**OXFORDSHIRE COUNTY COUNCIL’S RESPONSE TO CONSULTATION
ON THE FOLLOWING DEVELOPMENT PROPOSAL**

Application no: 22/01488/OUT

Proposal: Construction of up to 140,000 sq m of employment floorspace (use class B8 with ancillary offices and facilities) and servicing and infrastructure including new site accesses, internal roads and footpaths, landscaping including earthworks to create development platforms and bunds, drainage features and other associated works including demolition of the existing farmhouse

Transport Schedule

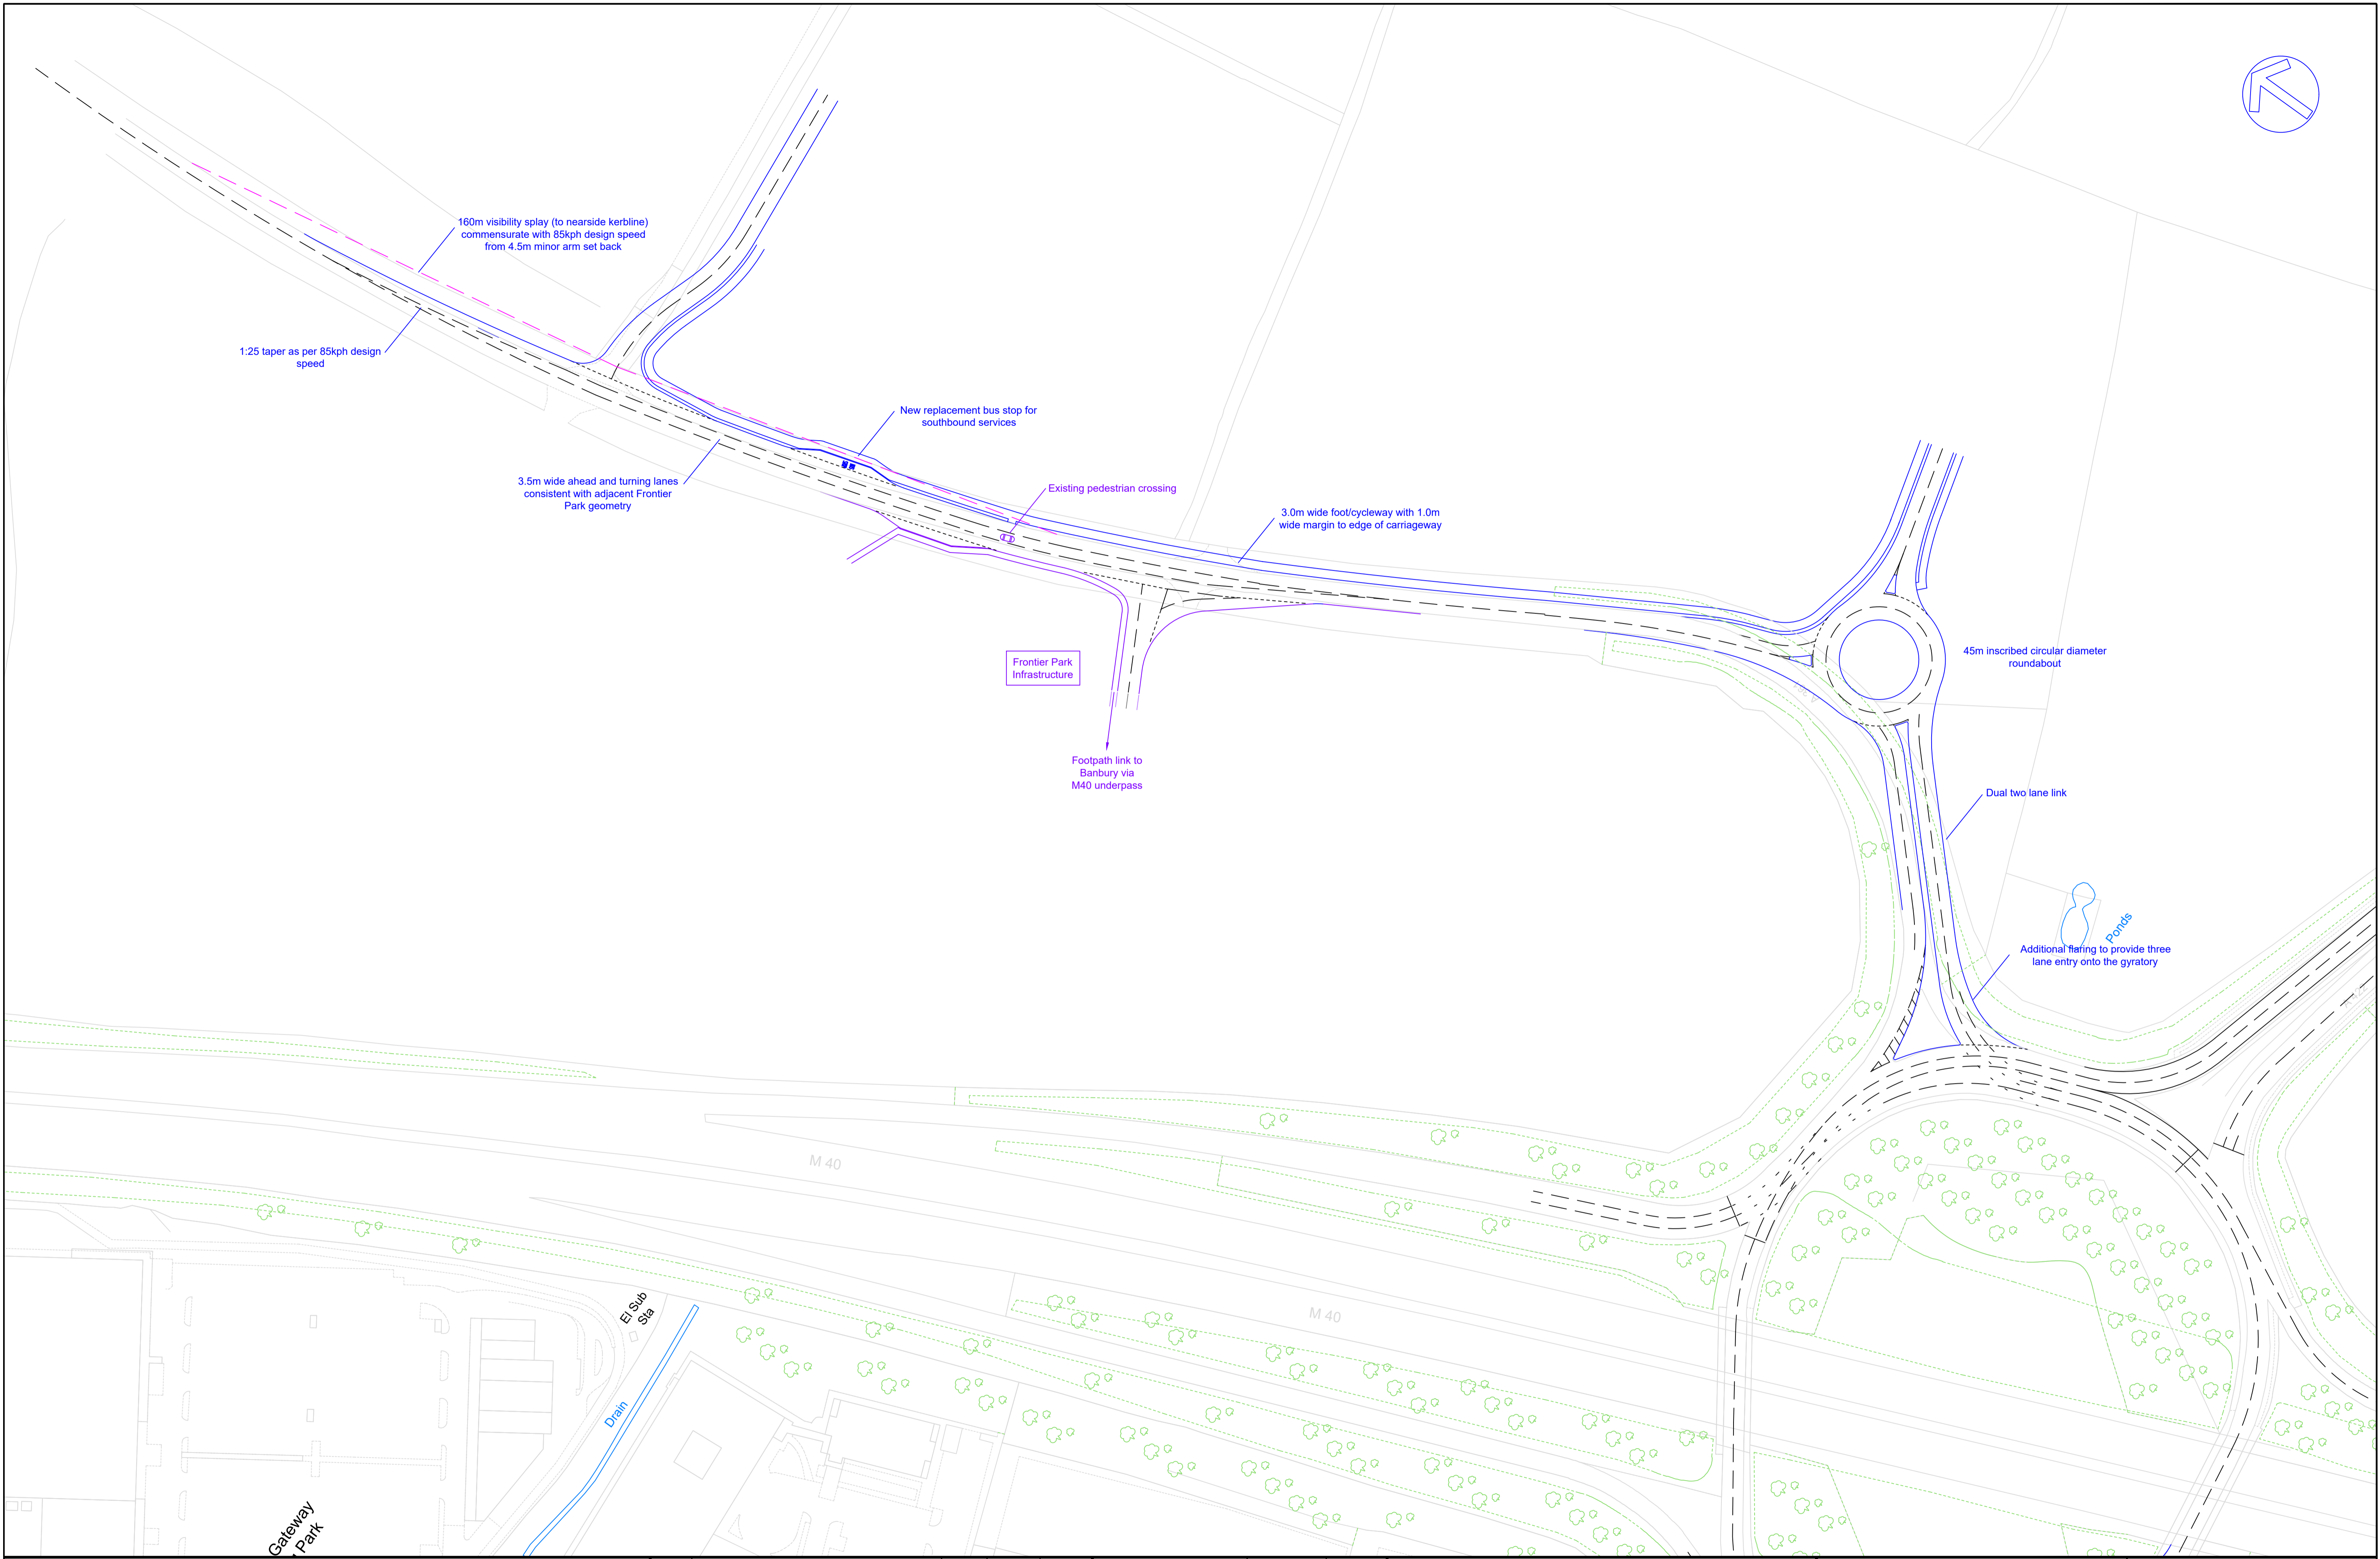
The primary access would be a three-arm roundabout located just a little over 100m from the A361 exit on to the Junction 11 roundabout. This proximity is likely to cause occasional severe congestion issues and is a reason for objection. See further discussion below under Traffic Impact. It has not been demonstrated that there is sufficient distance to accommodate the necessary direction signage.

The secondary access would be a priority junction, approximately 450m north of the primary access and approximately 200m north of the Frontier Park junction. A filter lane would be added to the A361 for right-turning inbound vehicles.

As the walking route would entail crossing the busy A361, a signalised crossing will be required, on the desire line between Frontier Park and the site access, to ensure pedestrian safety along the only available route.

demonstrated in a VISSIM simulation that widening the A361 to two lanes between the proposed and existing roundabouts, and increasing the gyratory entry flare to three lanes, is sufficient to mitigate for the effect of the additional vehicles. Also, it has not been demonstrated that these proposed highway modifications are feasible, considering the level differences between the carriageway and the surrounding land. Indicative cross-sections and the relation to the highway boundary should be included.
